Application for a non-material amendment following a grant of planning permission. Town and Country Planning Act 1990

M/111/14/NMA

Application for a non-material amendment following the grant of planning permission M/87/13/ to extend the approved layout a further 1m into the garden.

Drawing Title:
PROPOSED PLANS & ELEVATIONS
SITE PLAN

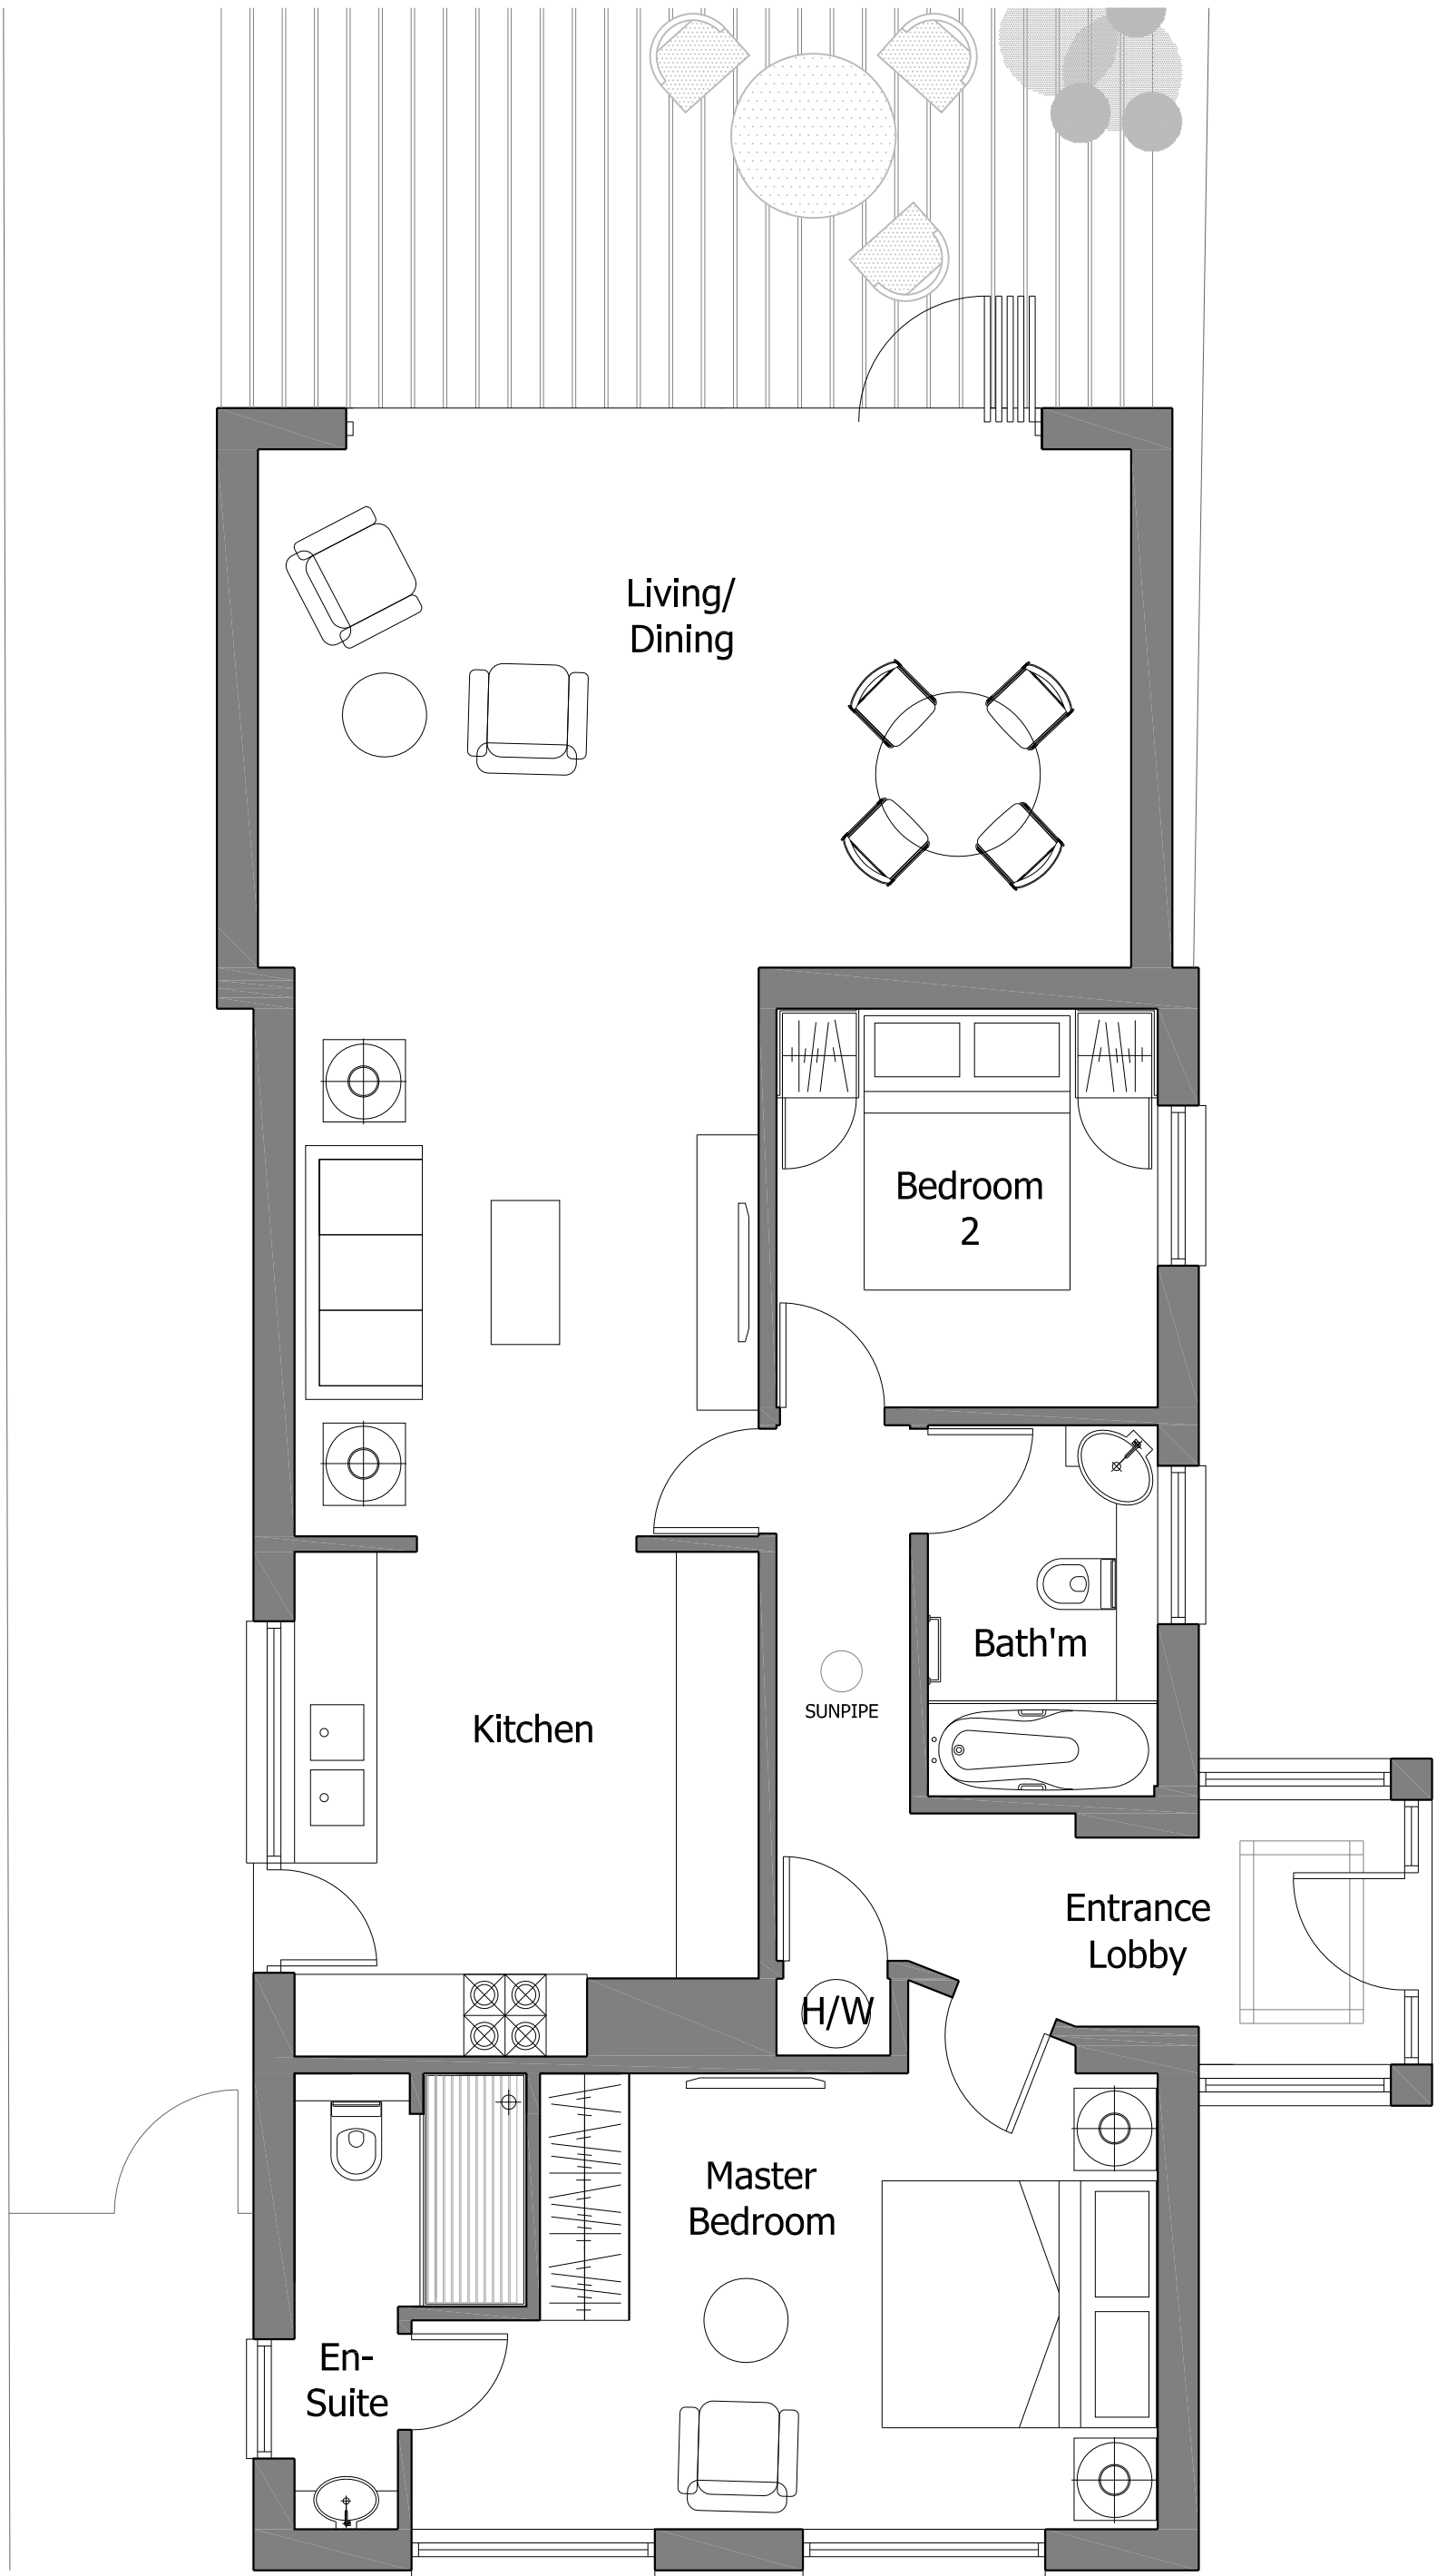
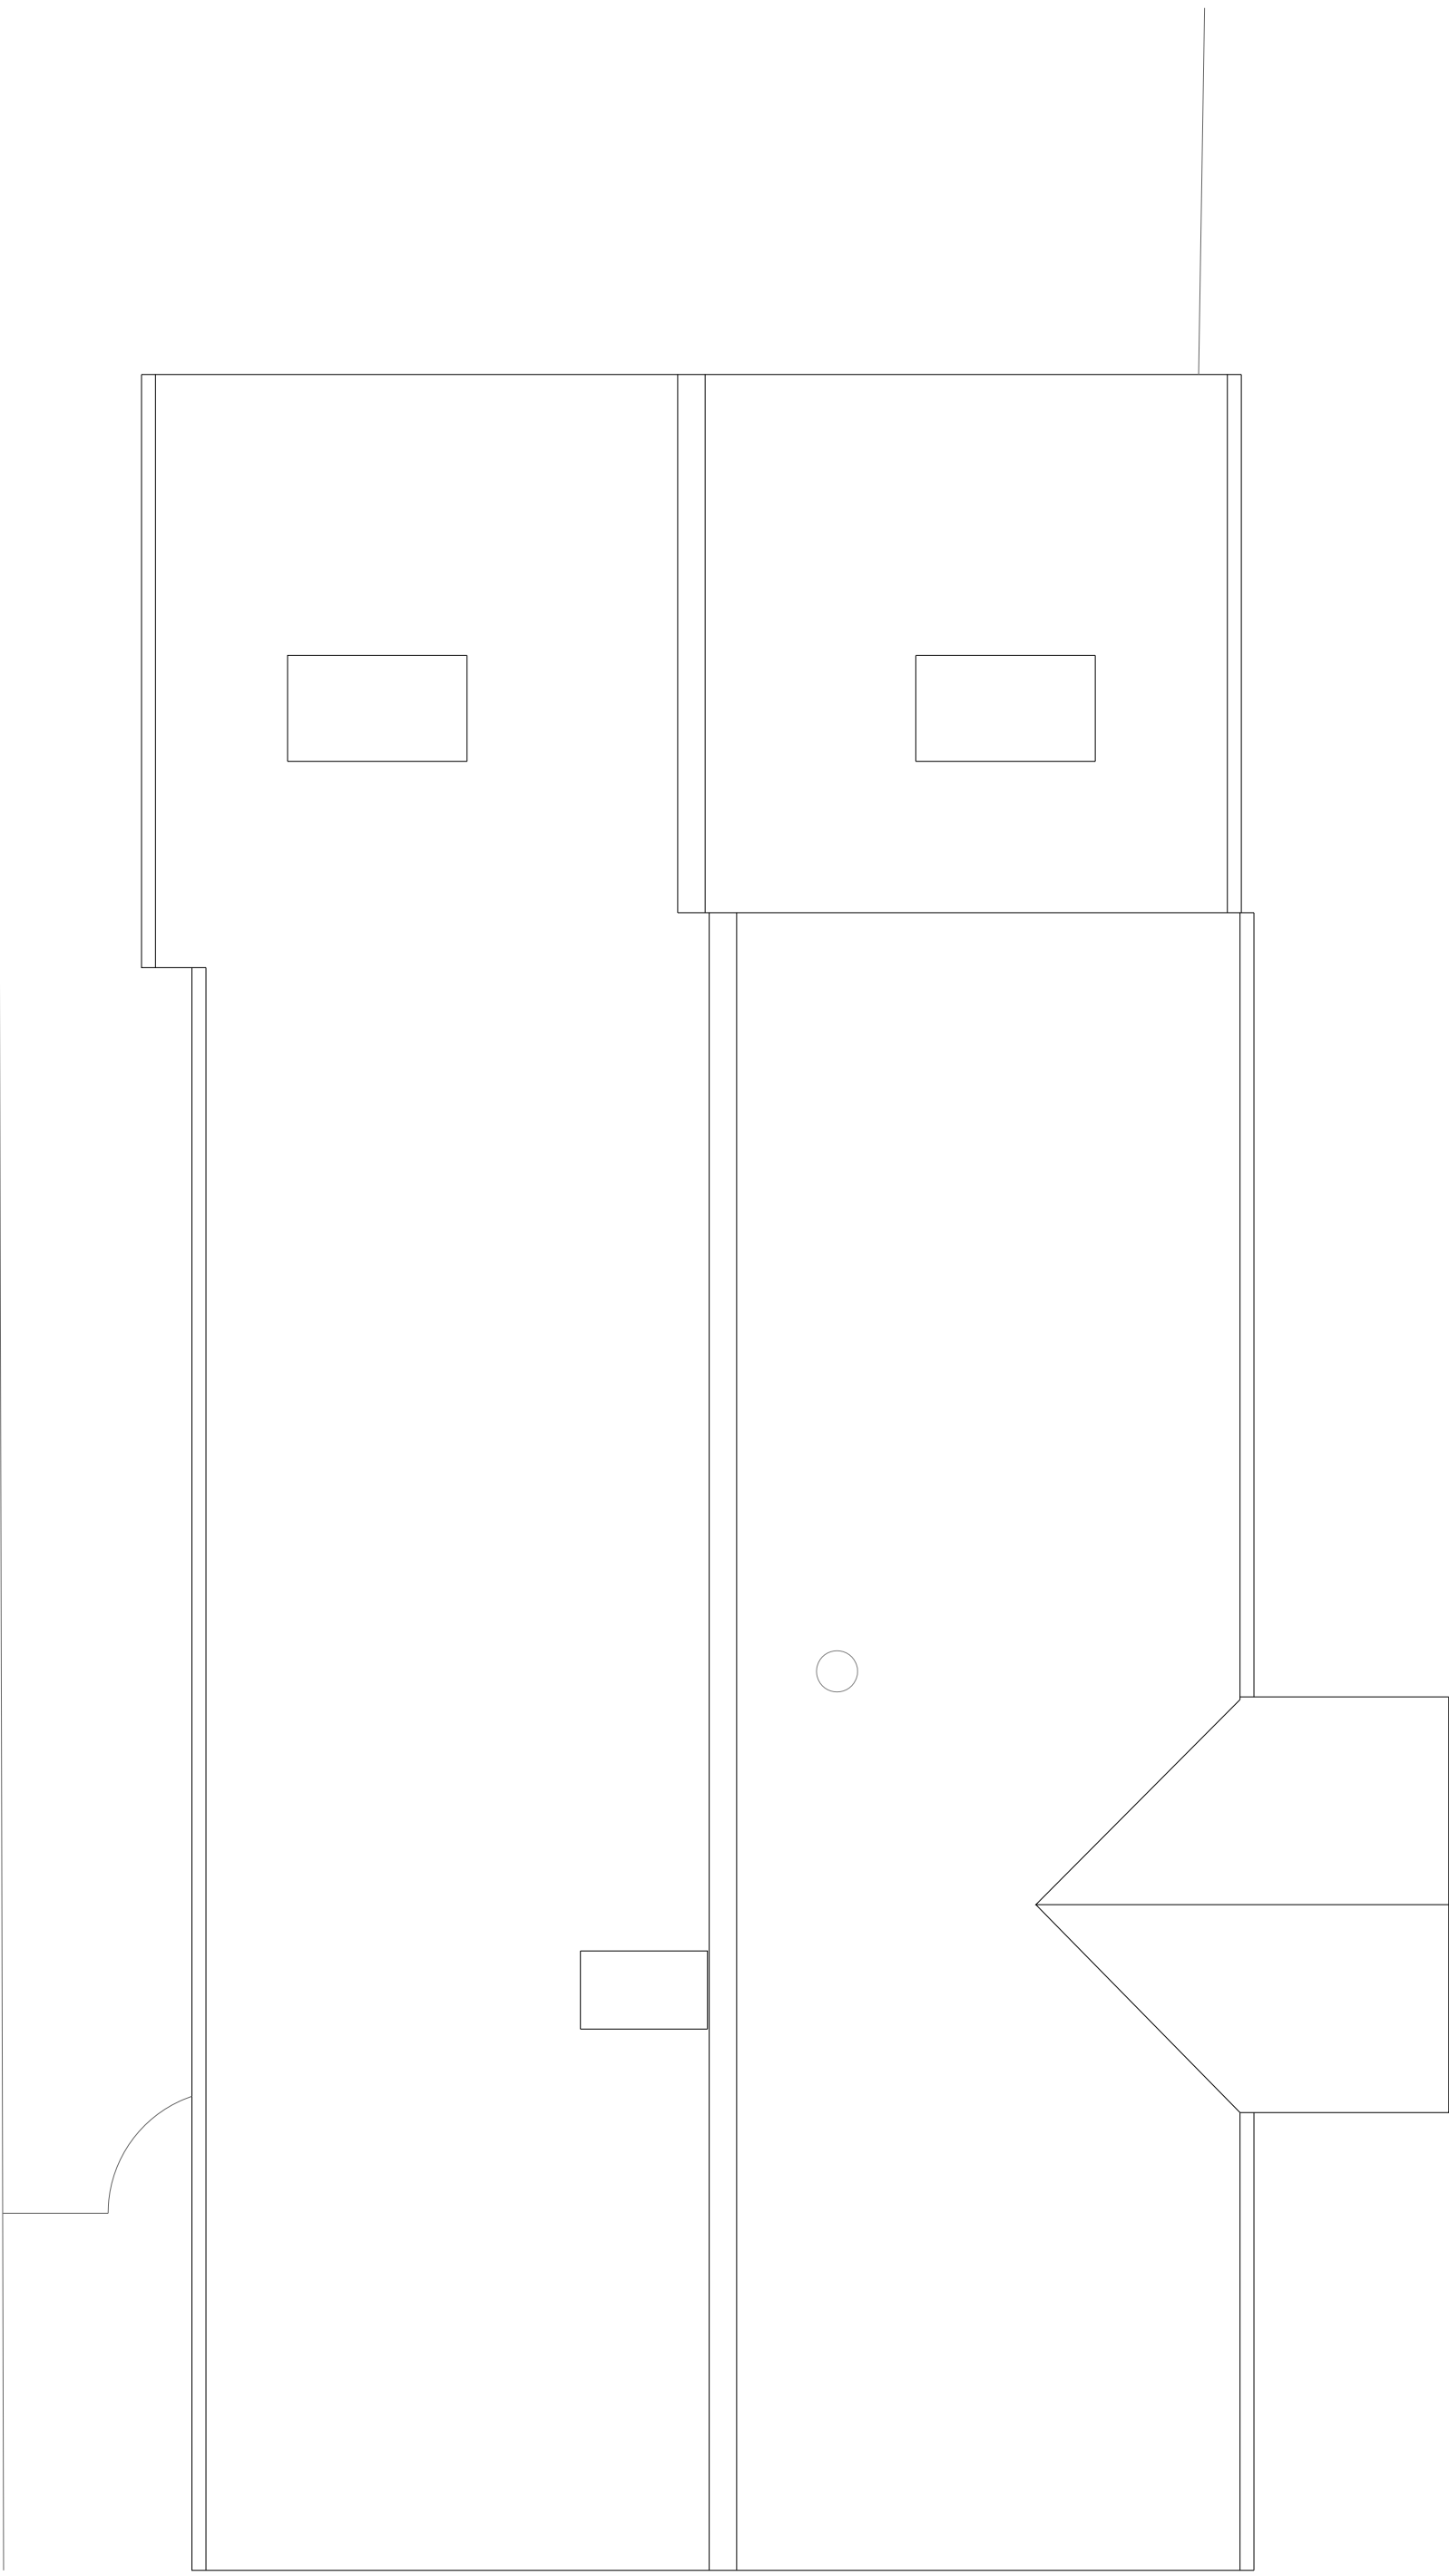
Extend the approved layout a further 1 metre into the garden

Old plan/drawing numbers: 1184 100, 101, & 102

New plan/ drawing numbers: 1184 100A, 101A, & 102A

I have looked at the proposed alteration and on the basis that it does not increase the depth of the extension by more than 1m I can advise that the amendment would fall within our adopted criteria and would be acceptable as a Non-Material Amendment. Without prejudice I would therefore suggest that you submit an application for consideration.
